Ribble Valley Borough Council
Council Offices
Church Walk,
Clitheroe
Lancashire
BB7 2RA

Phone: 0300 123 6780
Email: Kathryn.Walsh@lancashire.gov.uk
Your ref: 3/2024/0834
Our ref: 3/2024/0834/HDC/KW
Date: 03 February 2025

Location: 69 King Street Whalley BB7 9SW
Proposal: Proposed conversion of an existing retail unit with accommodation at first floor over into a boutique hotel with restaurant including three storey extension to side, two and three storey extensions to rear, building up and extension of existing rear outriggers with addition of windows and rooflights, roof terraces, new flue above ridge level, new bin store to side, new boundary treatment to side and rear and use of land to front and side for outdoor dining.
Grid Ref: 373309 436239

EXISTING SITE PLAN

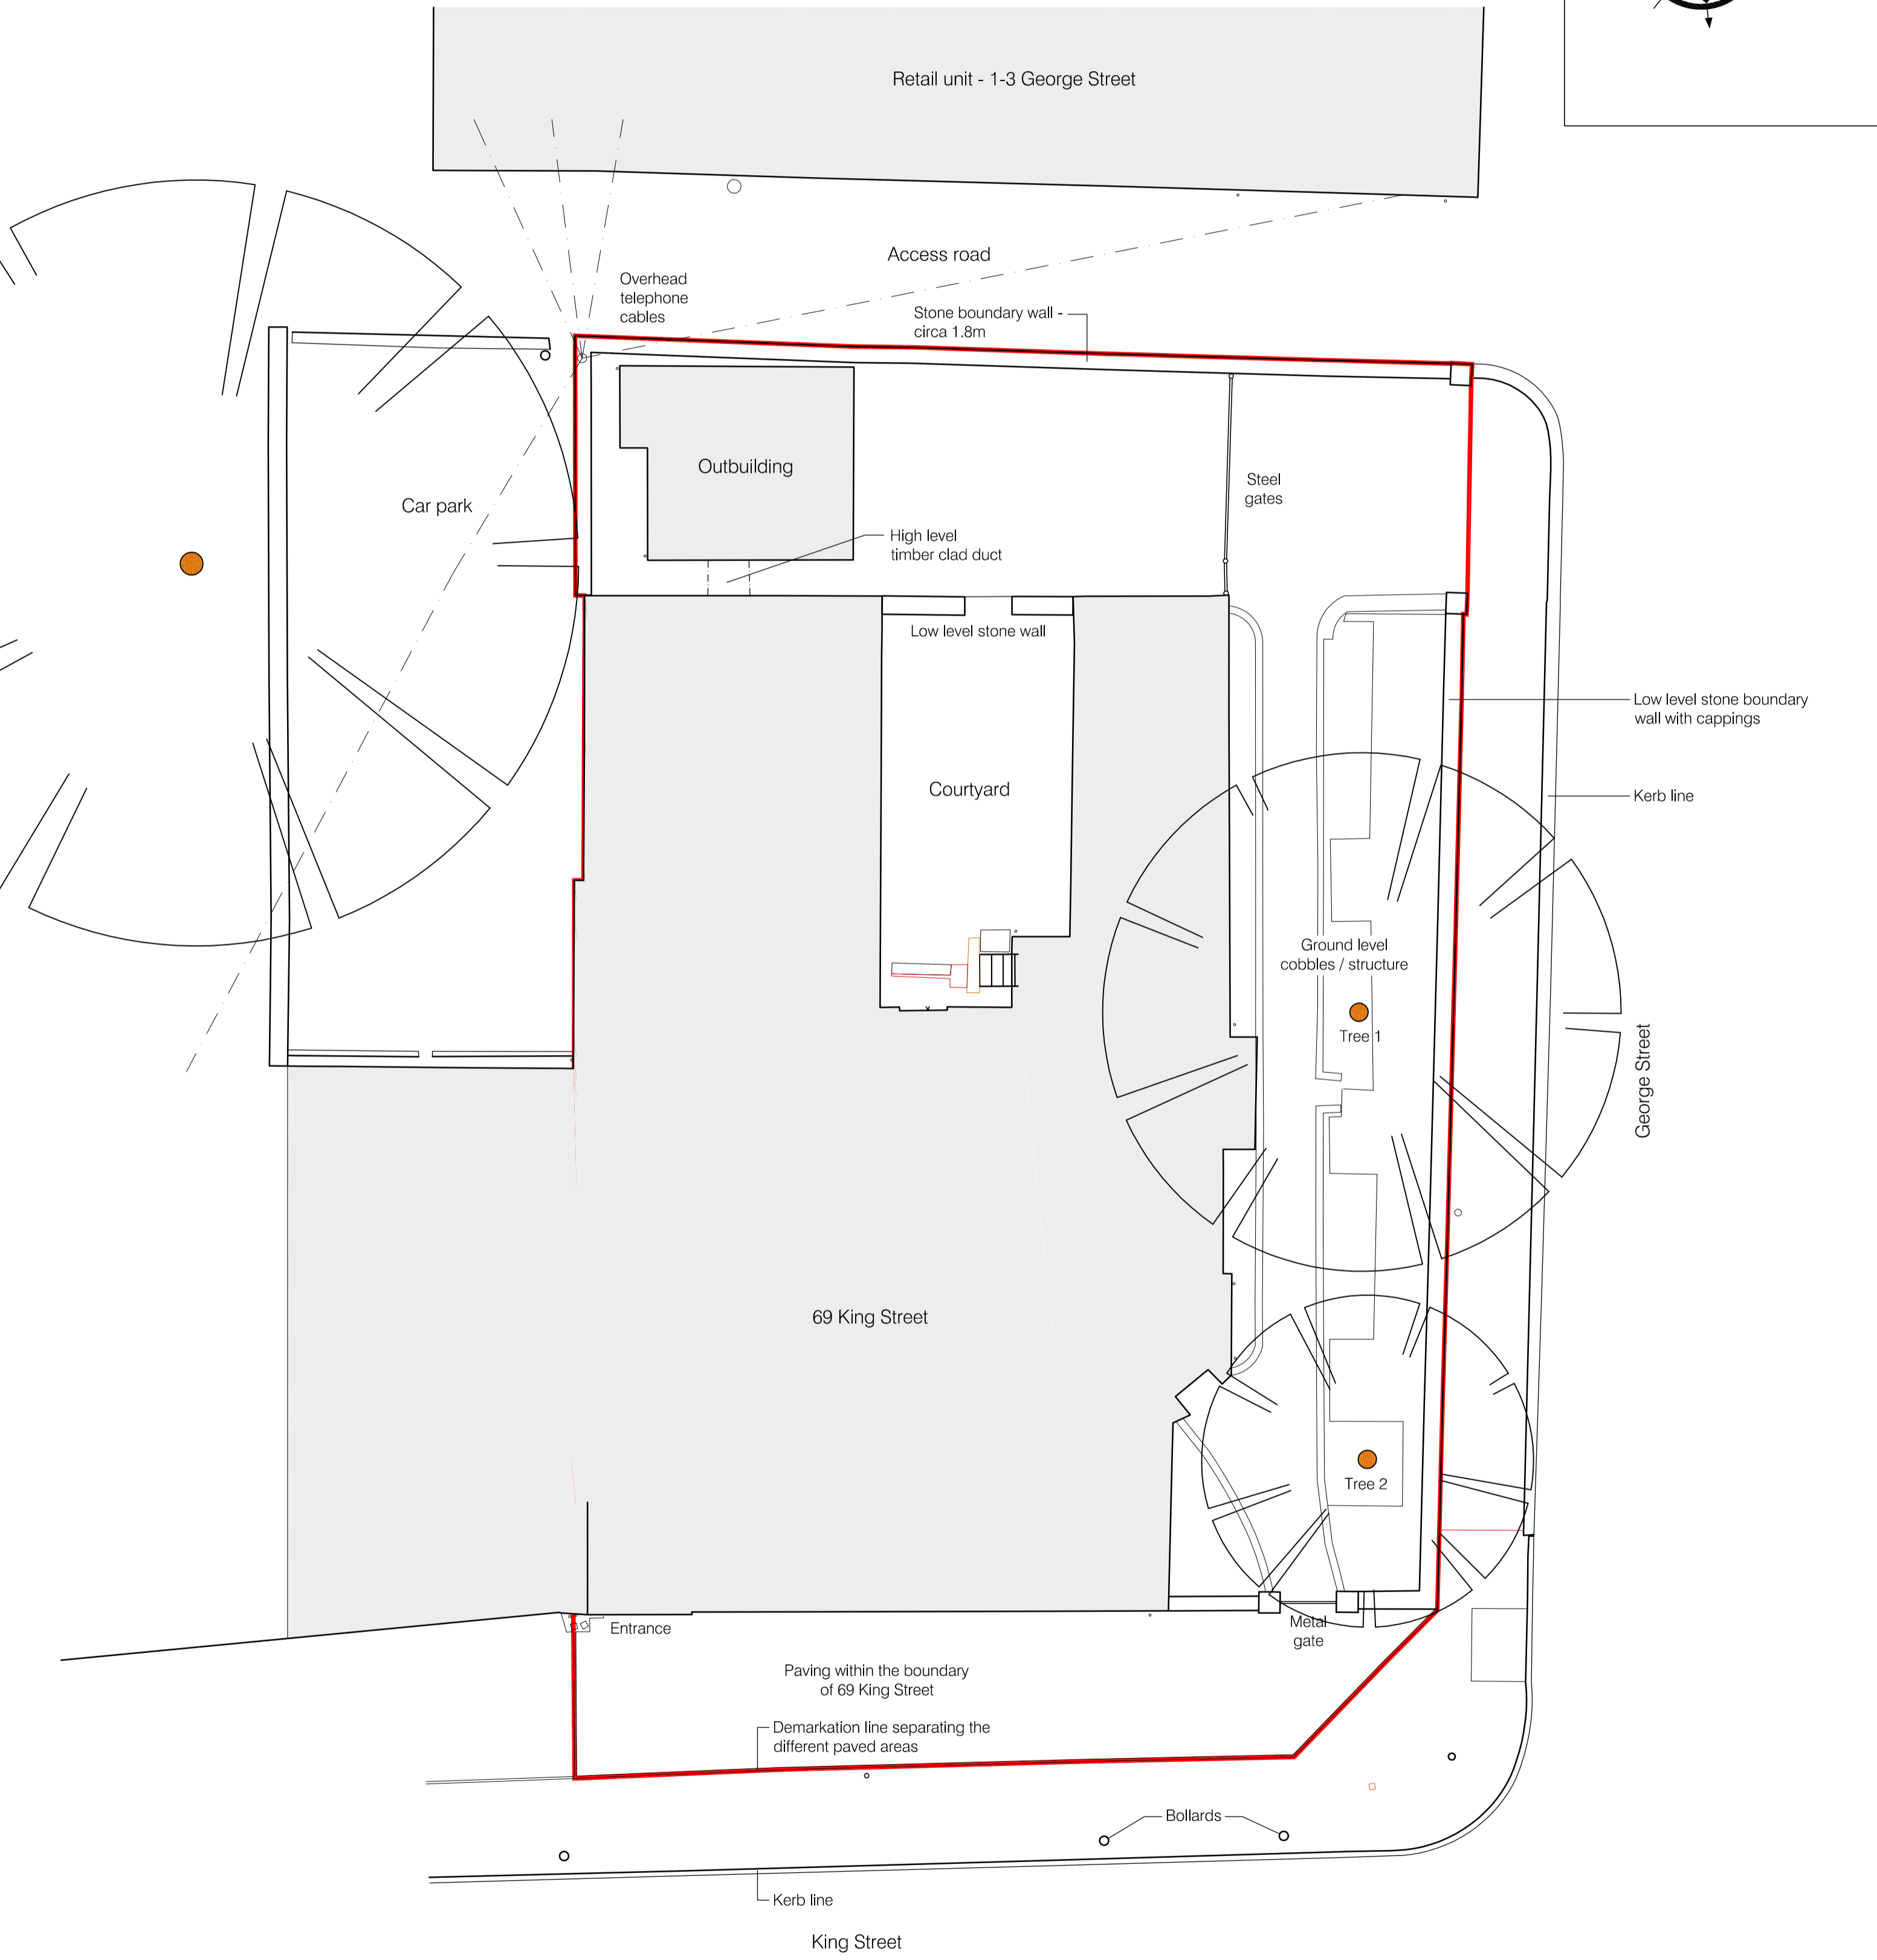
existing vehicle access on George Street which is an unclassified road subject to a 20mph speed limit.

Given the proposed extension, this area would become unsuitable for vehicles in its proposed form, therefore it would be required that the applicant enter into an appropriate legal agreement with Lancashire County Council to have the current vehicle crossing removed if the application is to be granted permission.

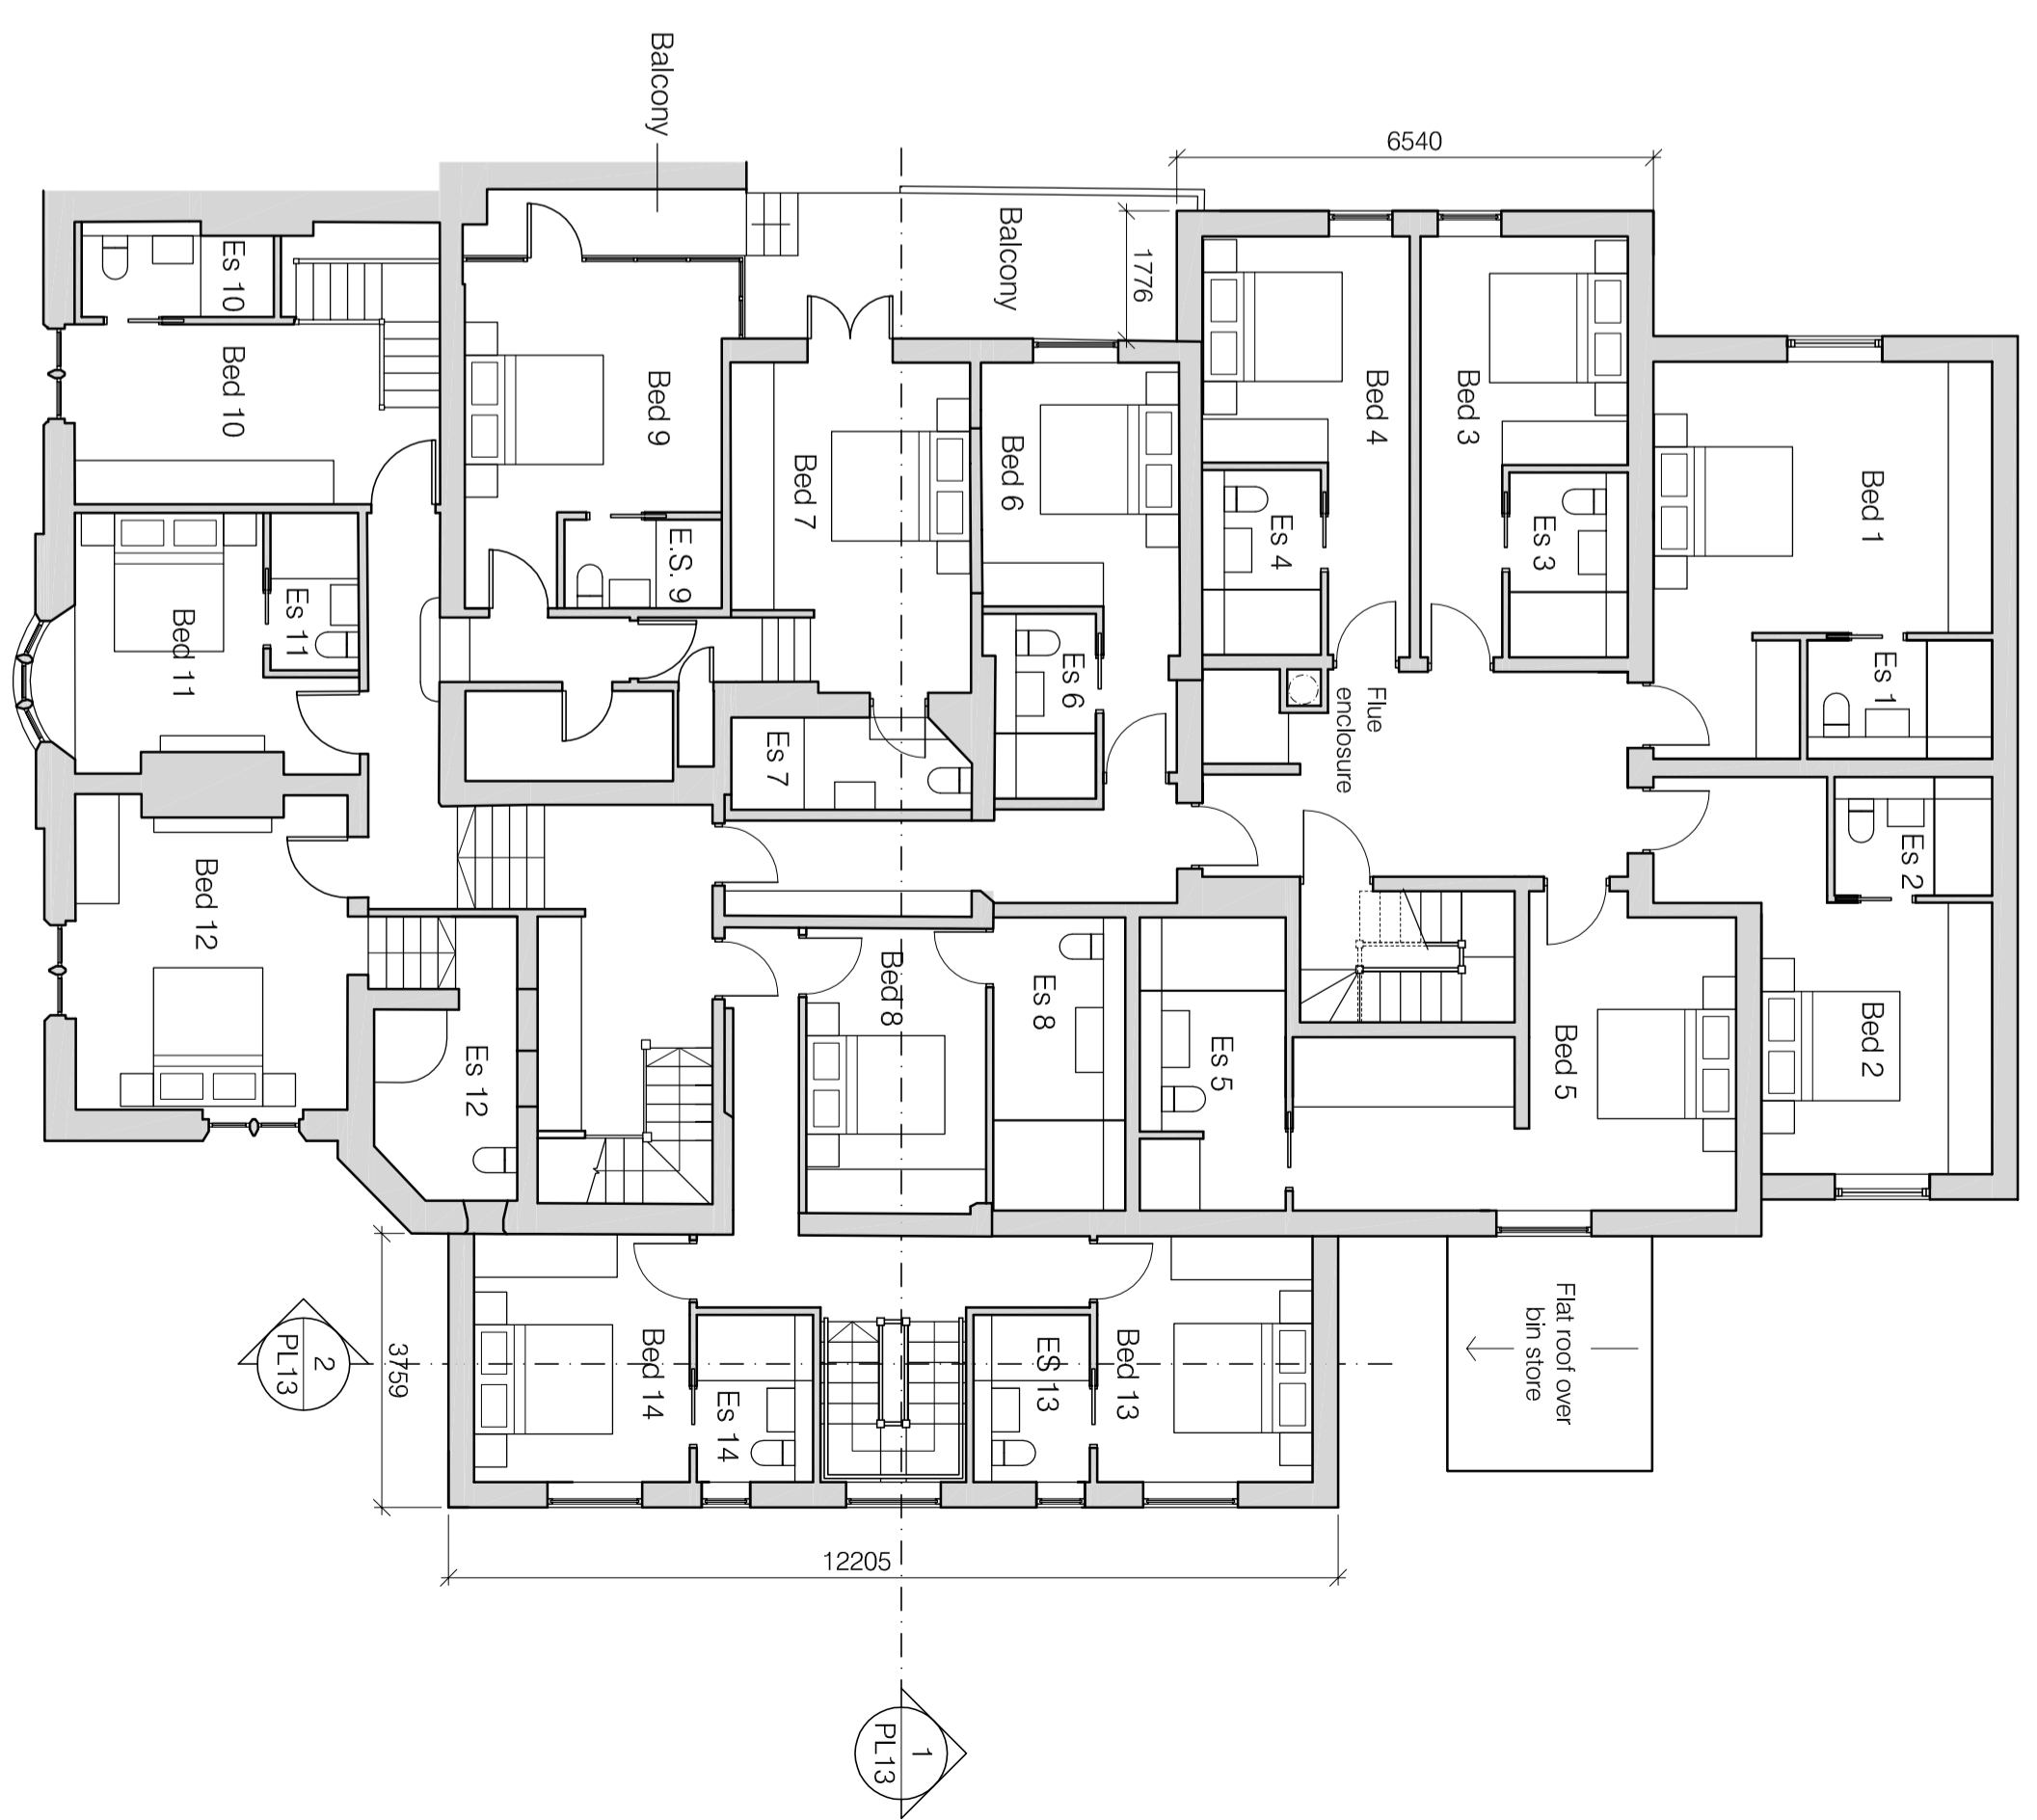
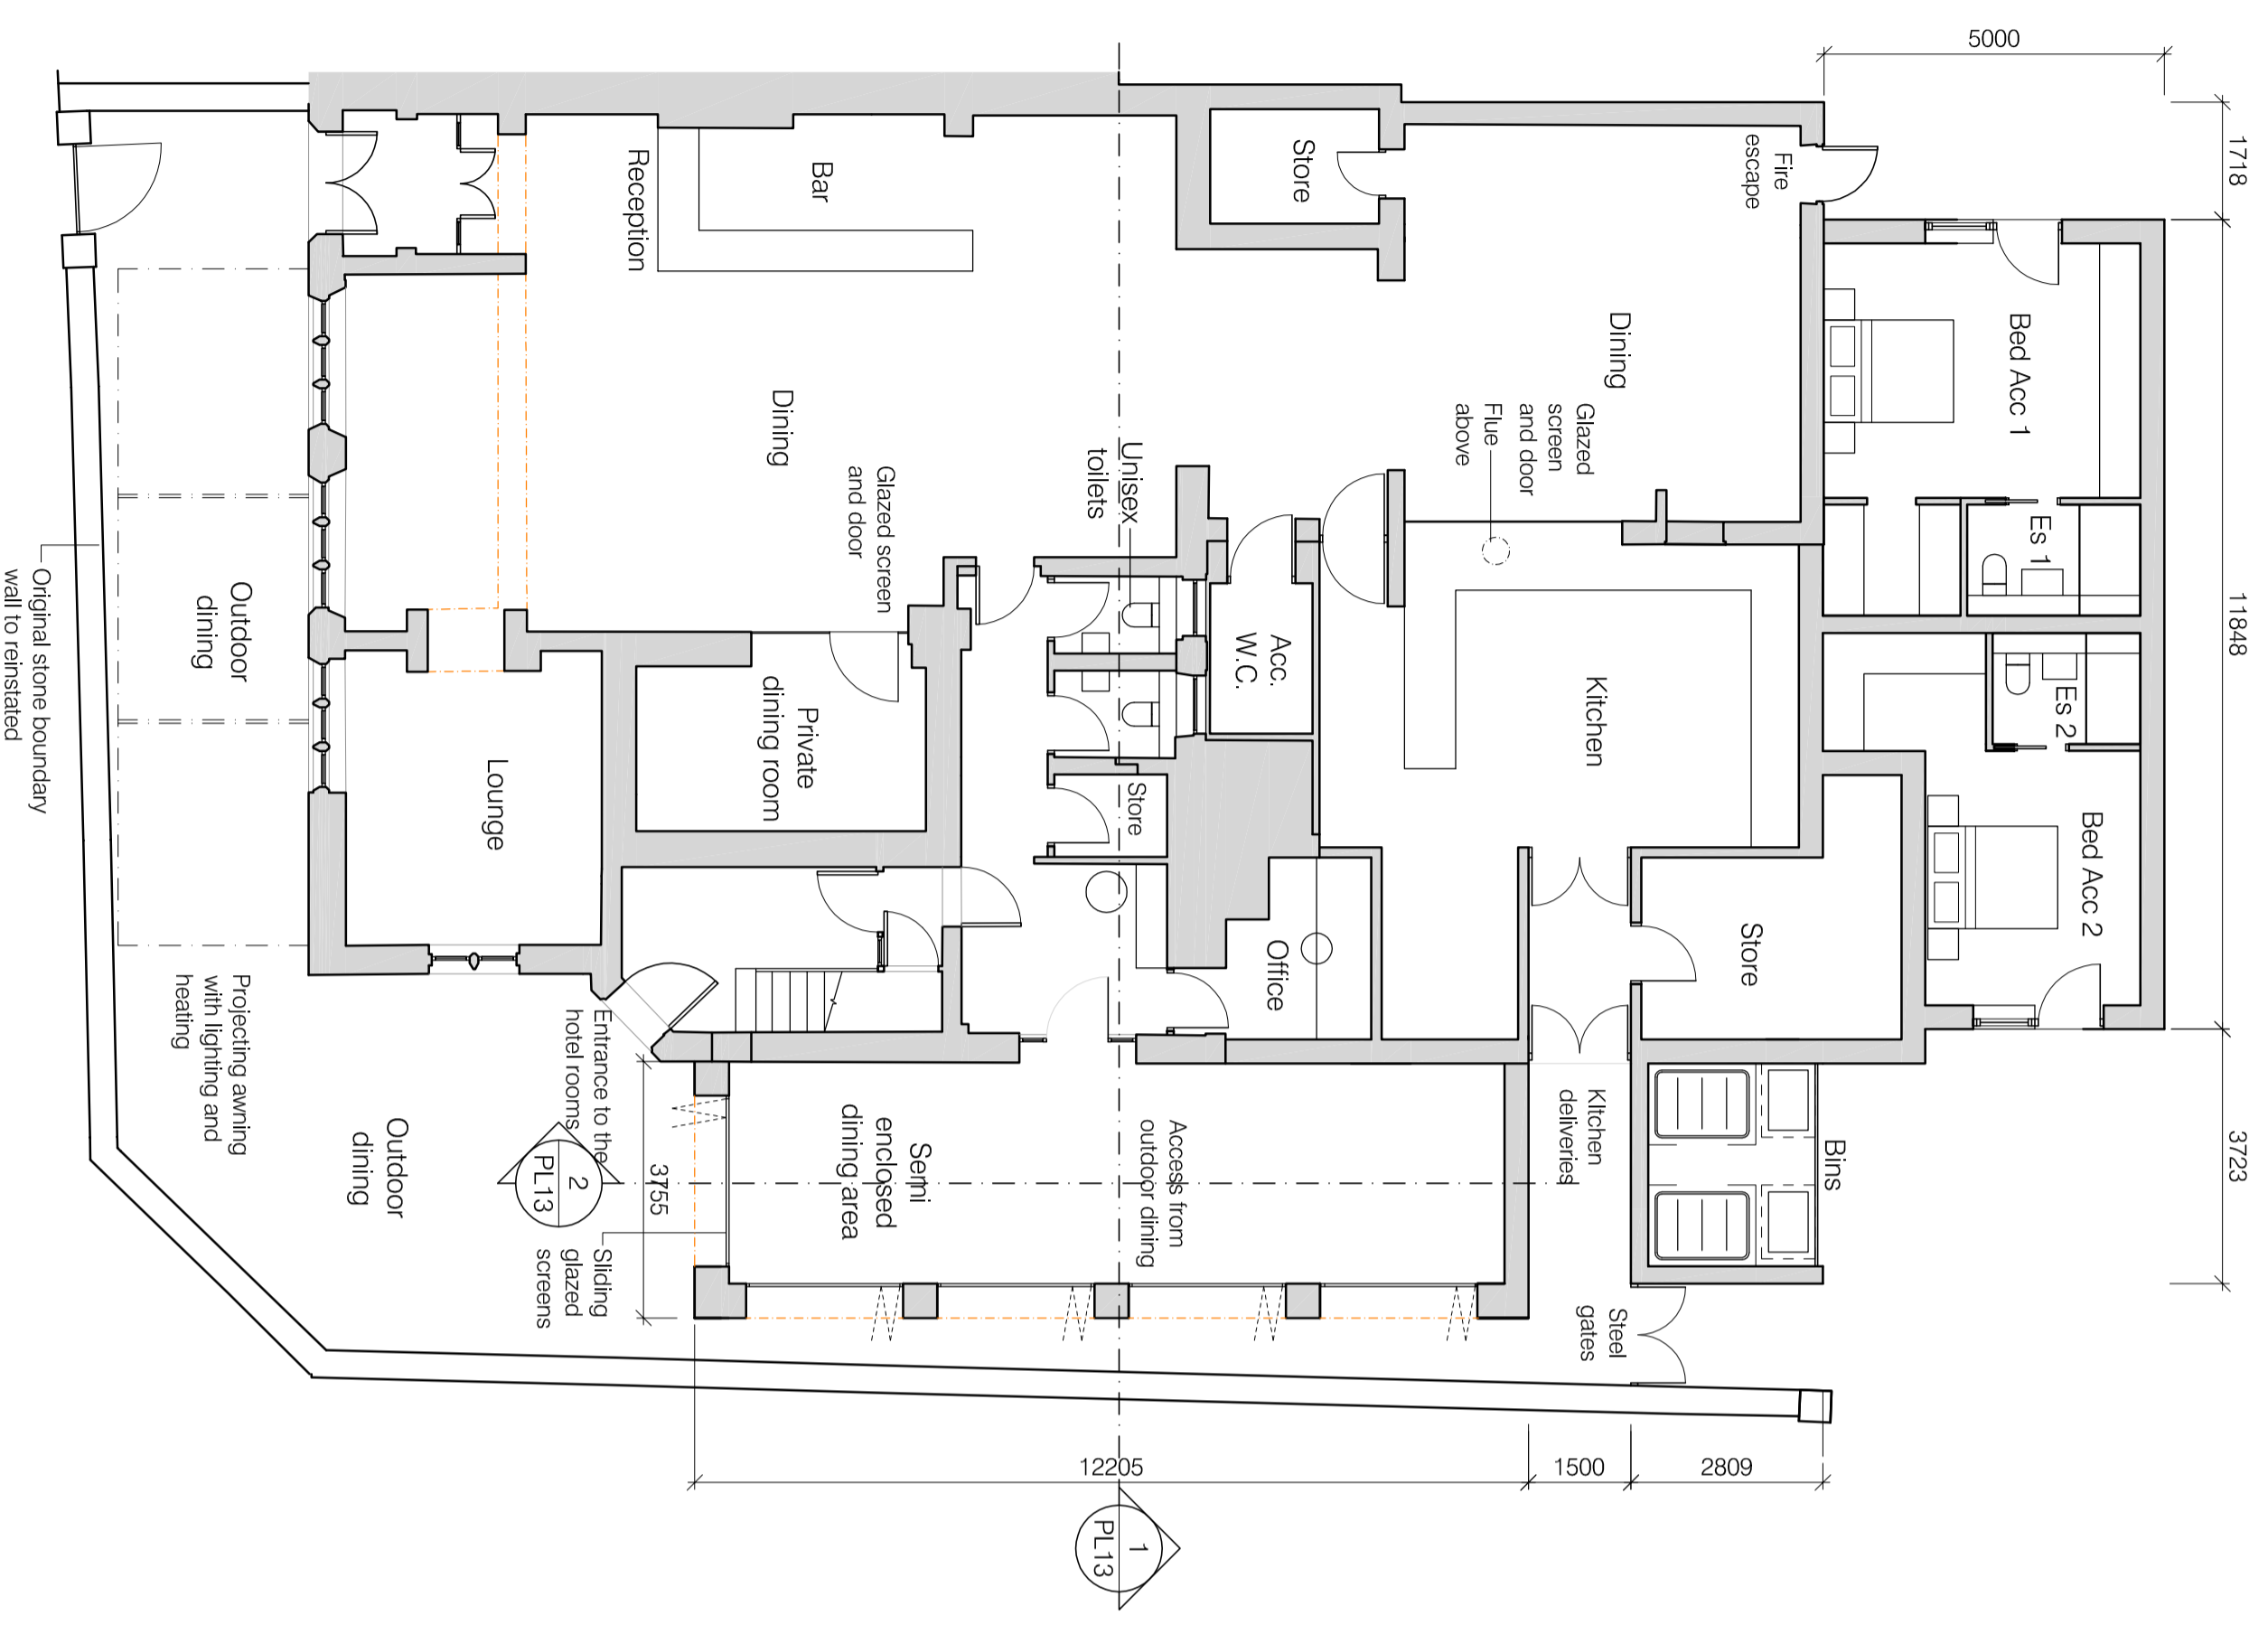
The LHA require further information regarding the floor area of the proposed dining areas and the number of covers the site can achieve. This information will support the LHA in determining demand. This should cover not only the indoor dining area but also the outdoor dining area too.

The LHA usually require a site which has a restaurant to provide 1 car parking space per 8 square metres of dining floor area.
